Subject: FW: Planning Consultation on: BE/30/19/PL

Engineers Comments Regarding Surface Water Drainage

APPLICATION **BE/30/19/PL**

Description of Works: Retention of secure containers, welfare facilities & secure
fencing together with associated landscaping works.

DRAWING TITLE
SITE LOCATION AND BLOCK PLANS

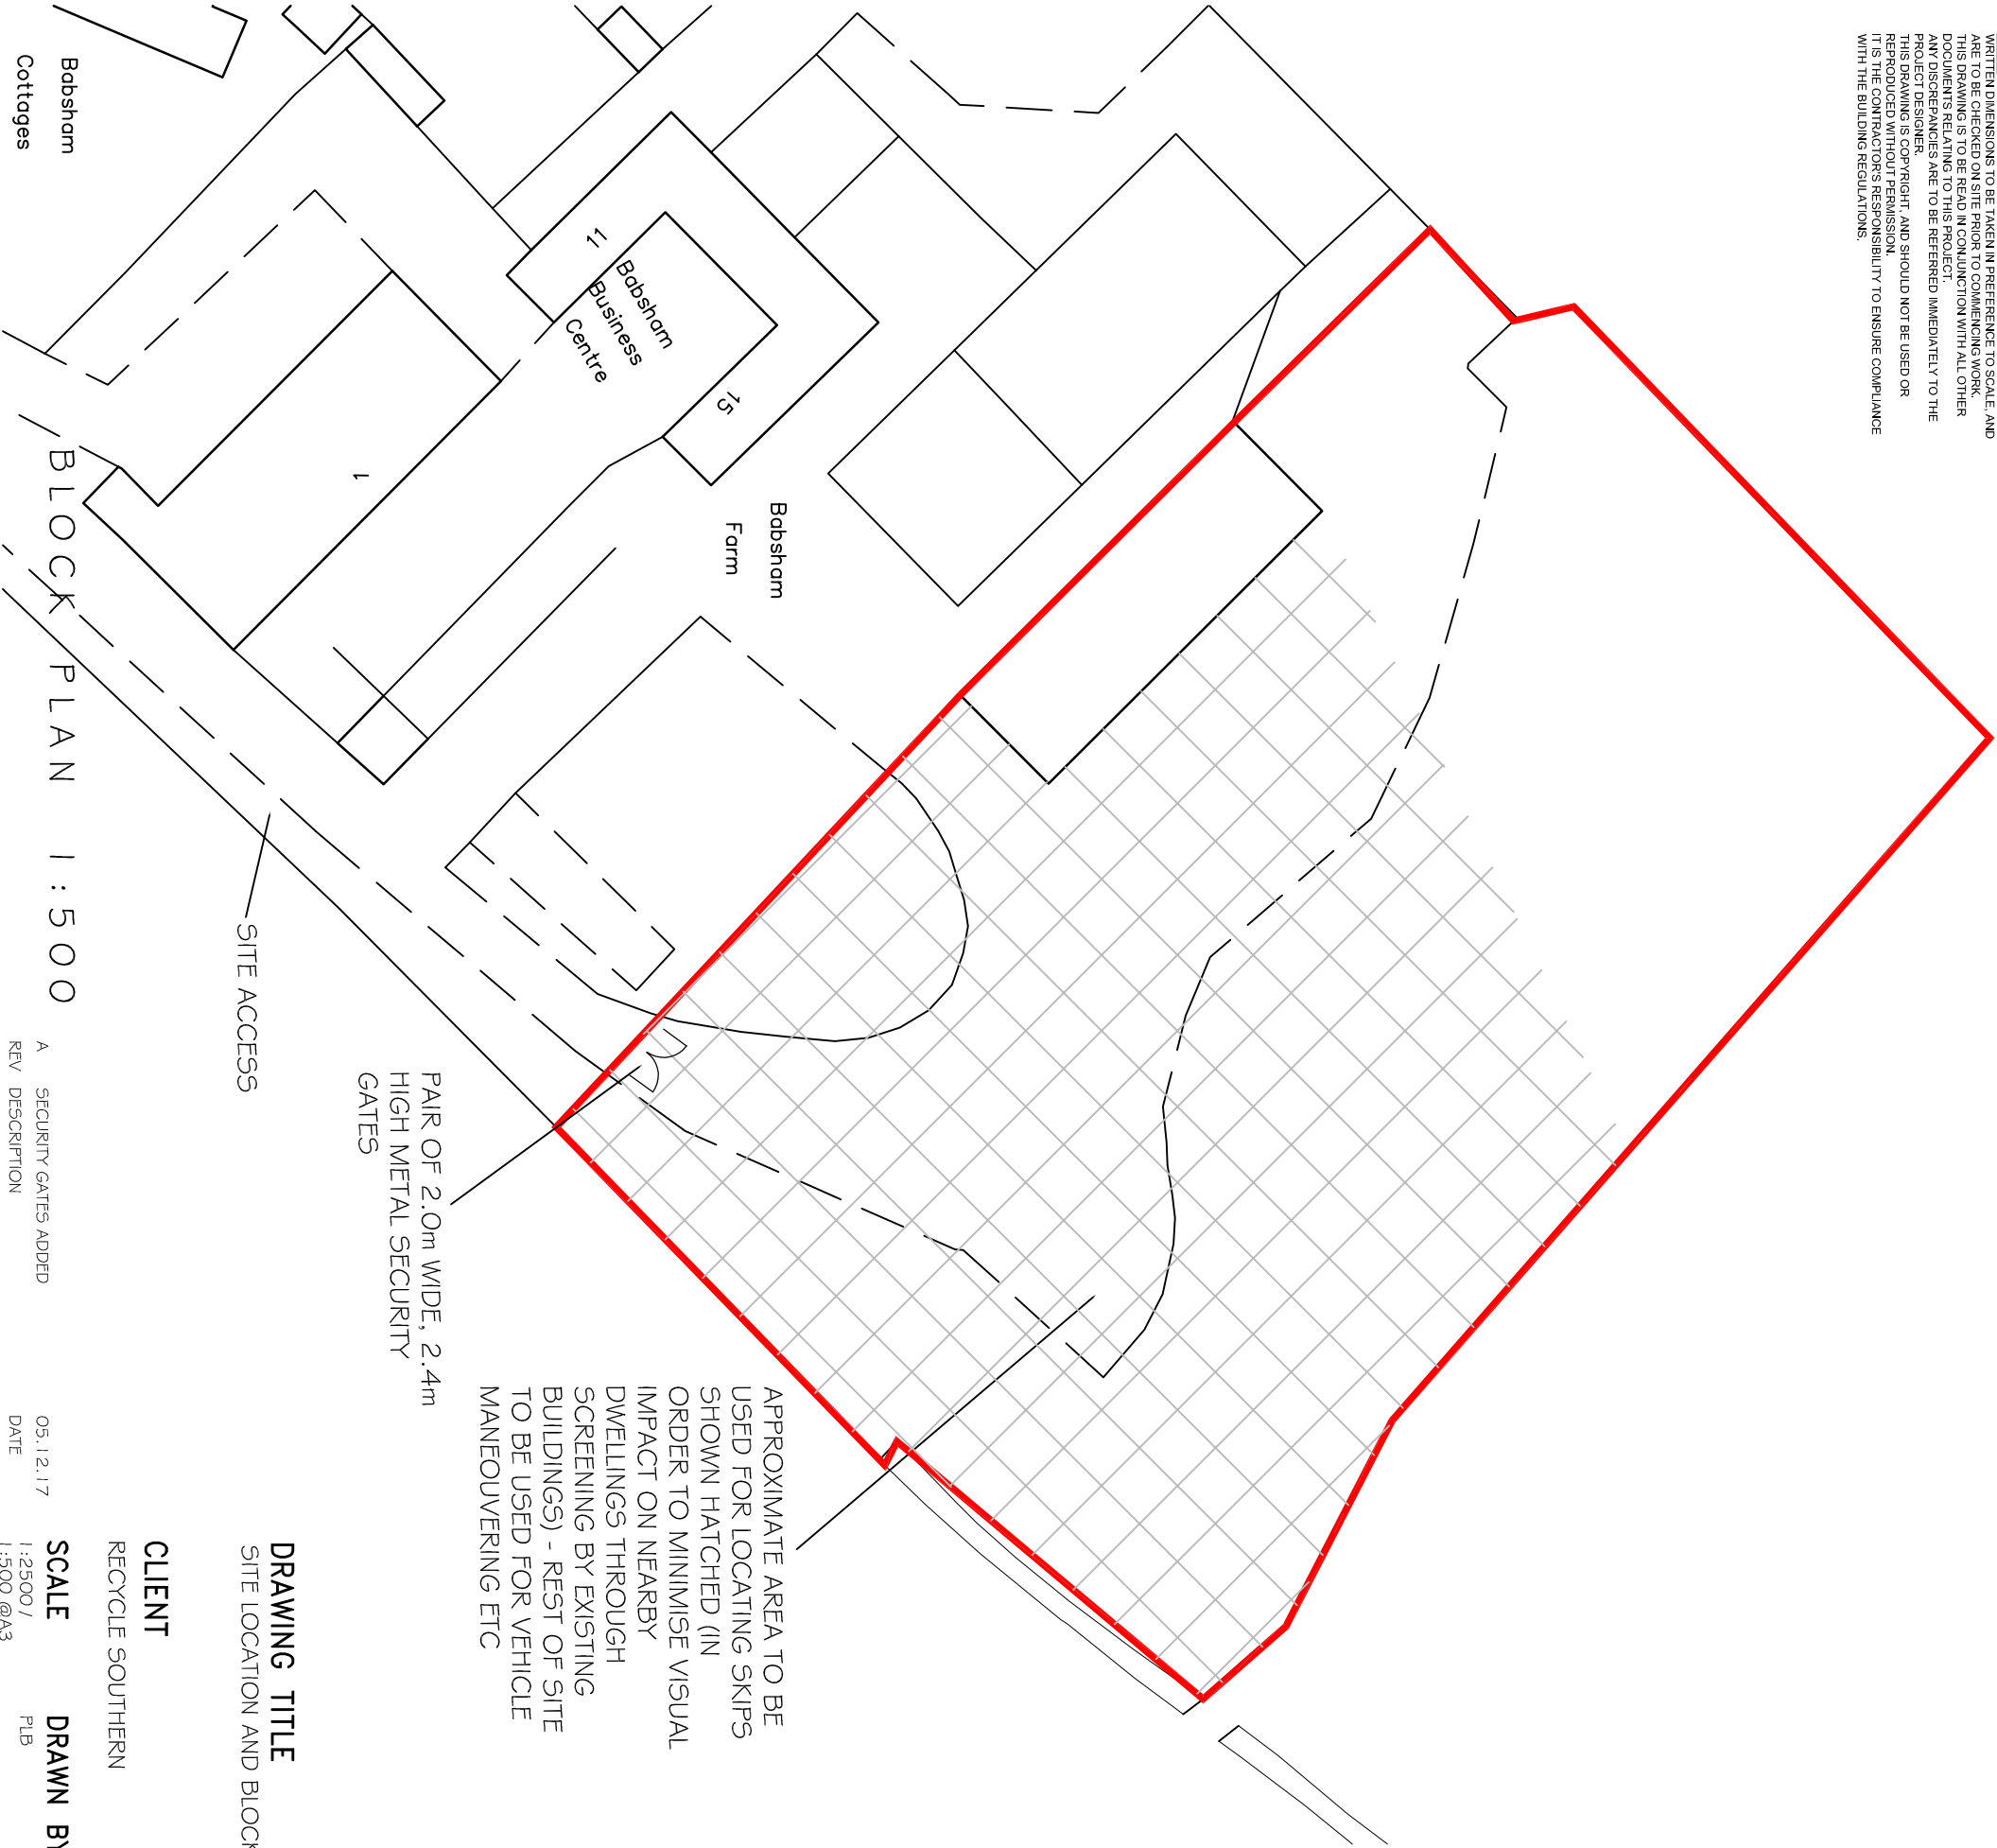
There is an ordinary watercourse along the south east corner of the site. Development must be kept a minimum of 3m away from the top of bank of this watercourse. I.e. we would not permit the proposed bund to be located as close as is shown on the proposed layout plan. Please can the applicant remove the bund from proposals or locate it away from the watercourse.
